Application number: 2024/92546	
What is the application for?:	Erection of front porch and front and rear dormers, application of render and al
Address of the site or building:	3, Greenway, Honley, Holmfirth, HD9 6NQ
Postcode:

User comments

East Elevation

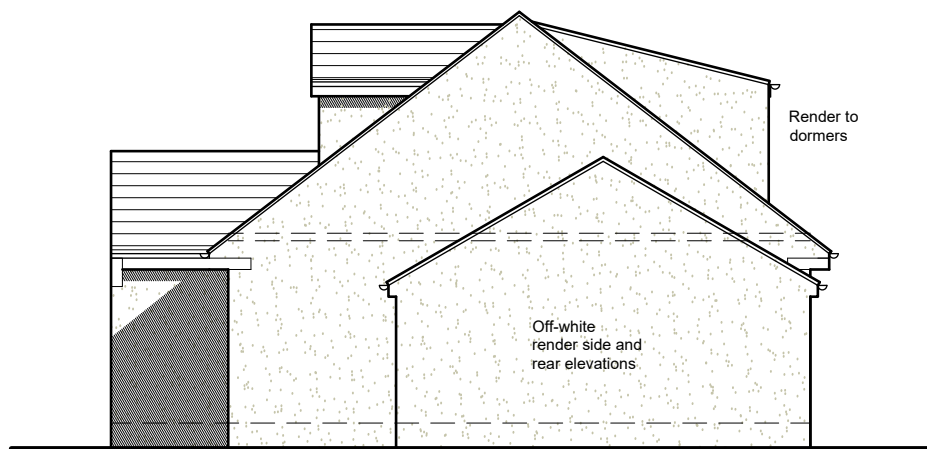
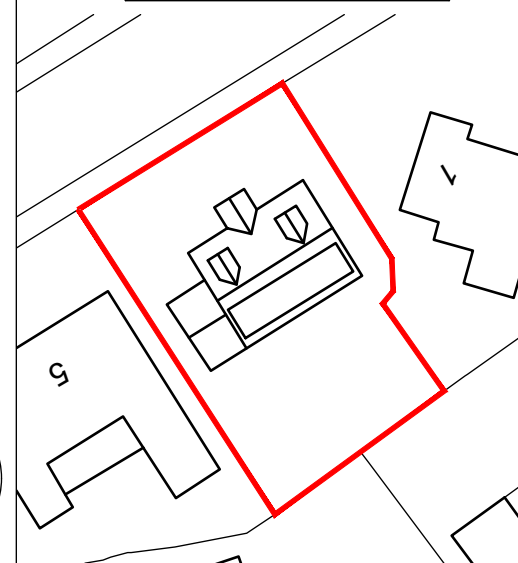
Type of comment: A general comment	
Do you wish your comments to be published on the website anonymously?	<input type="checkbox"/> Yes
We do not believe that the off white rendering to the 2 side elevations is appropriate to this conservation area. All other houses on greenway have retained the brick or stone original facias.
